PROJECT: HERITAGE PROPANE SITE CONDITIONAL USE PERMIT CHARLOTTE, NORTH CAROLINA

SHEET TITLE: PROPOSED SITE LAYOUT

SUBJECT: Administrative Approval for Petition No. 96-41 by D. L. Phillips Investment Builders, Inc.

**PHILLIPS INDUSTRIAL PARK
BARRINGER ROAD SECTION
LOT "A" AND LOT "B"
SCHEMATIC DEVELOPMENT PLAN**

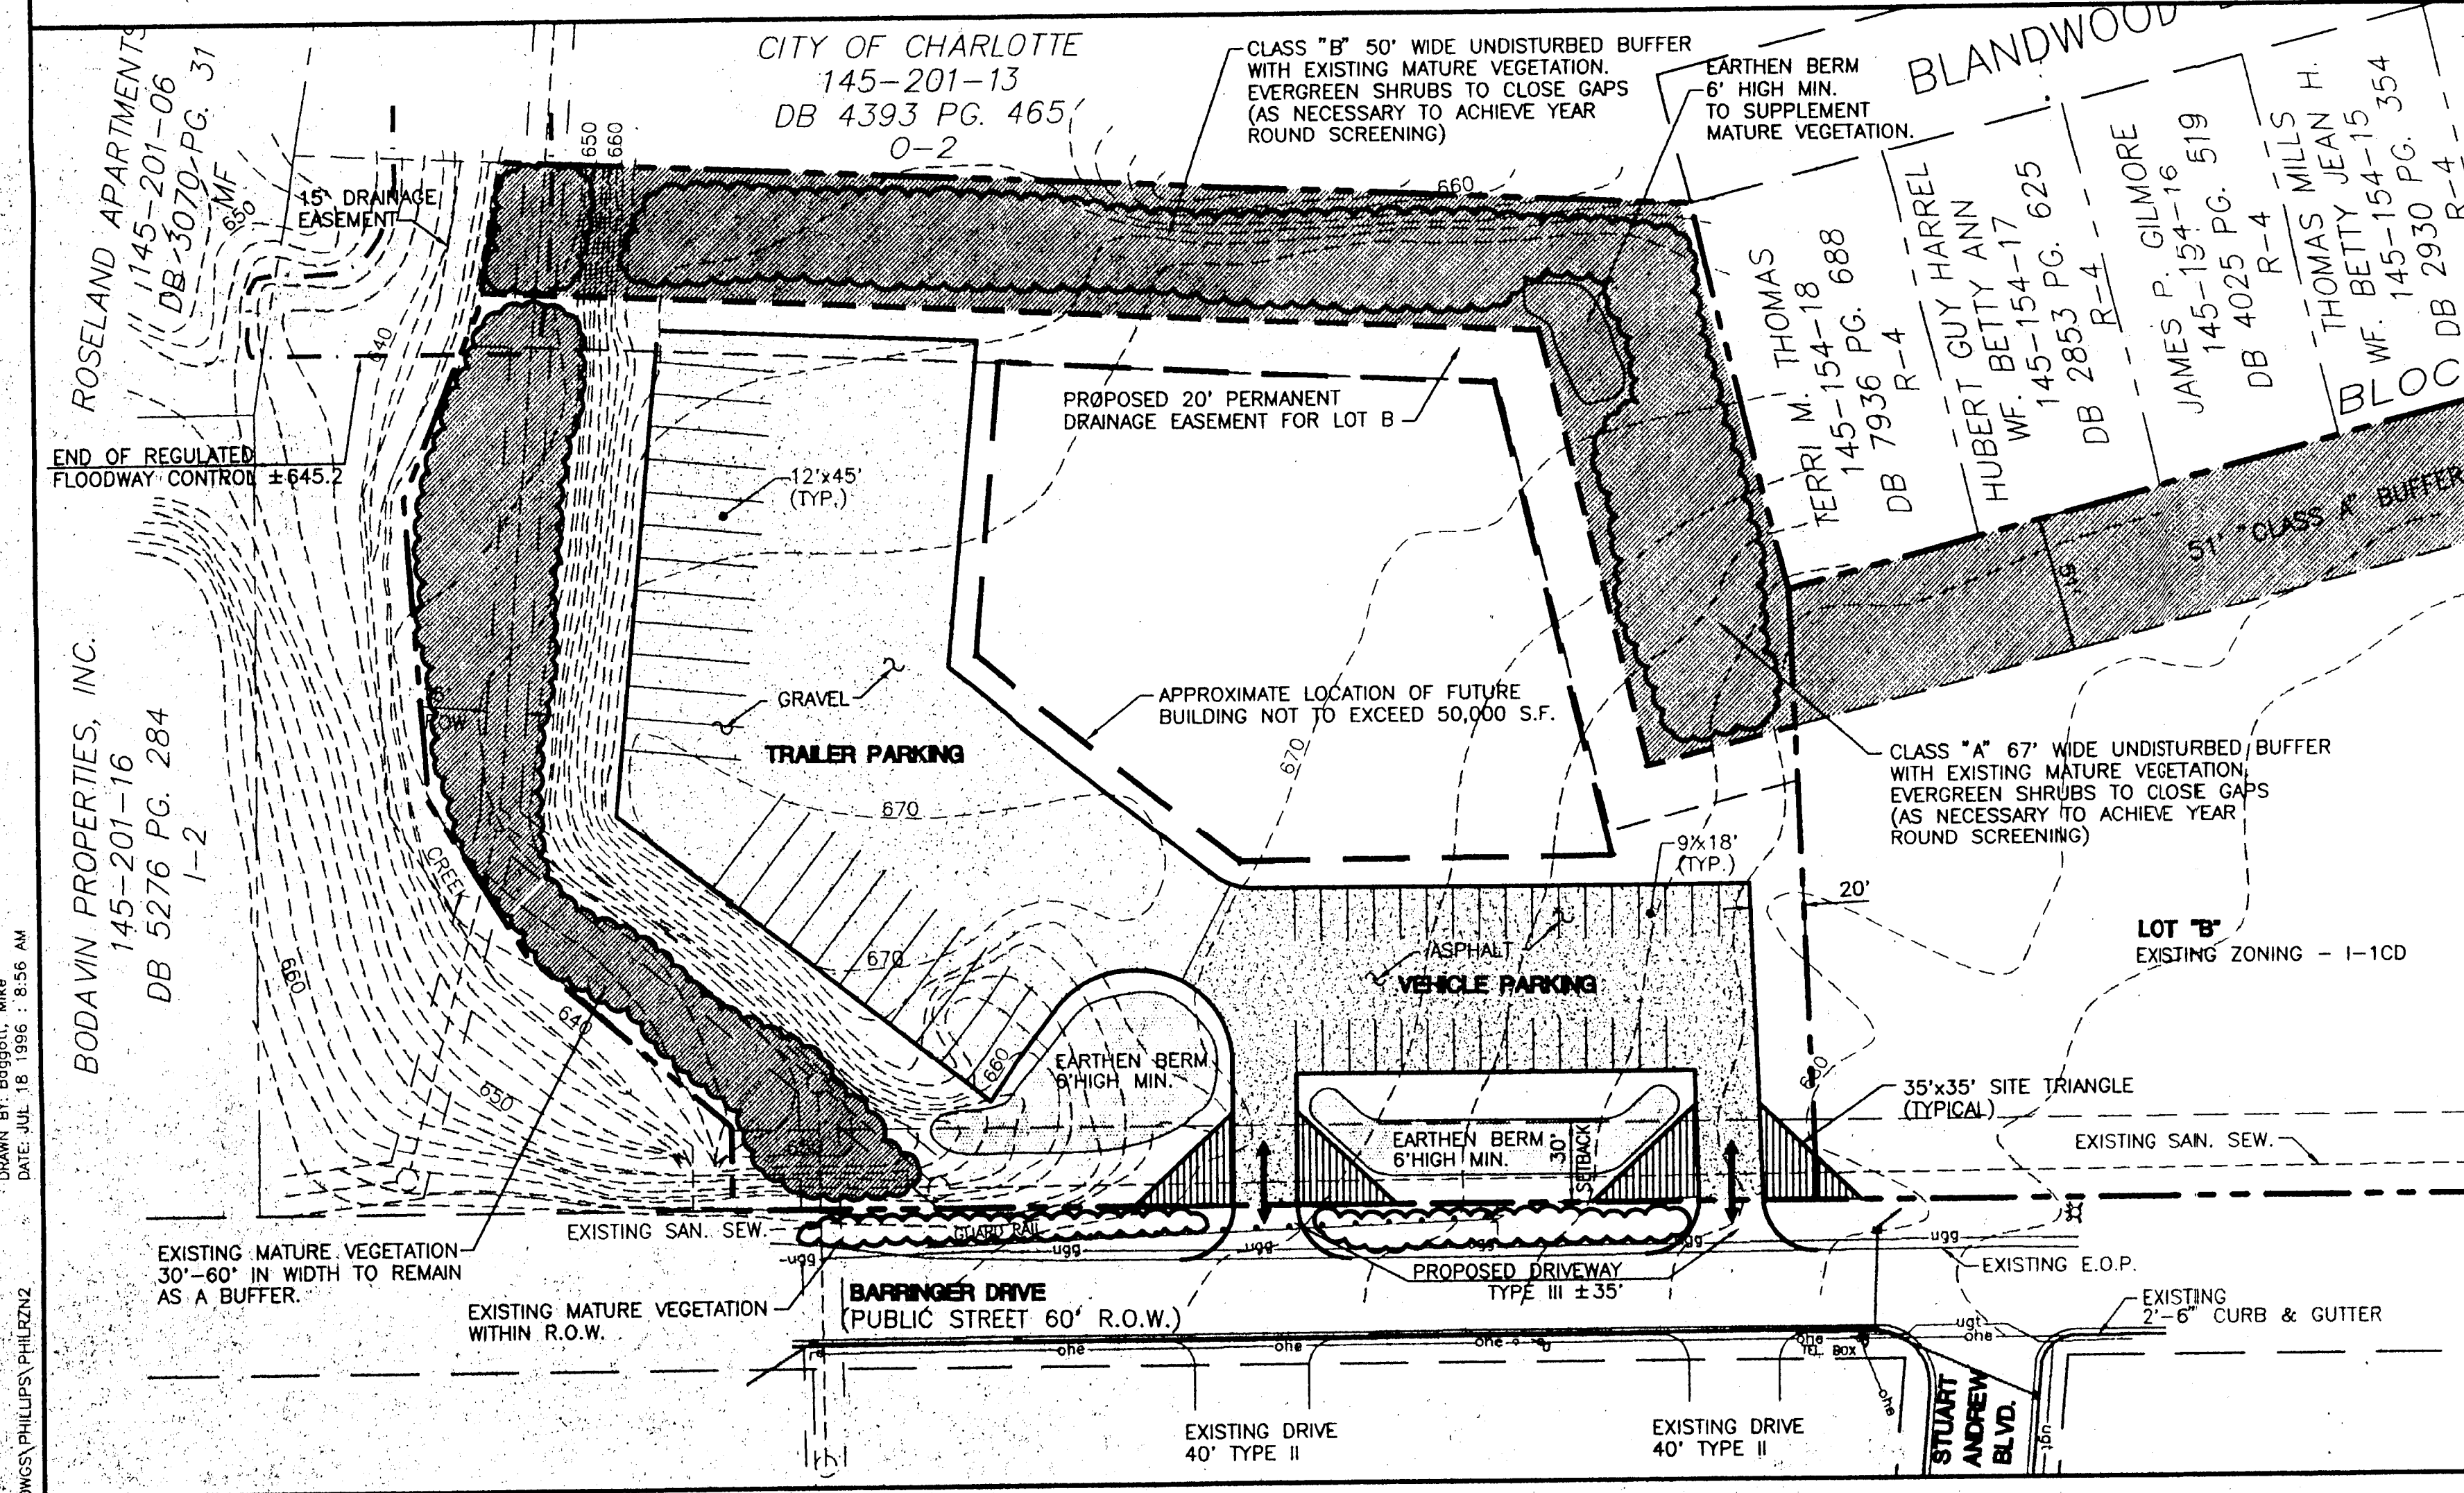
Attached is a revised plan for the above rezoning petition. The plan has been revised to indicate propane gas storage and sales as an allowed industrial use (this is a clarification) and to eliminate the berm along Barringer Drive. Since these changes are minor and do not alter the intent of the approved plan, I am administratively approving this revised plan. Please use this revised plan when evaluating requests for building permits and certificates of occupancy. **Note this site must still meet all other ordinance requirements.**
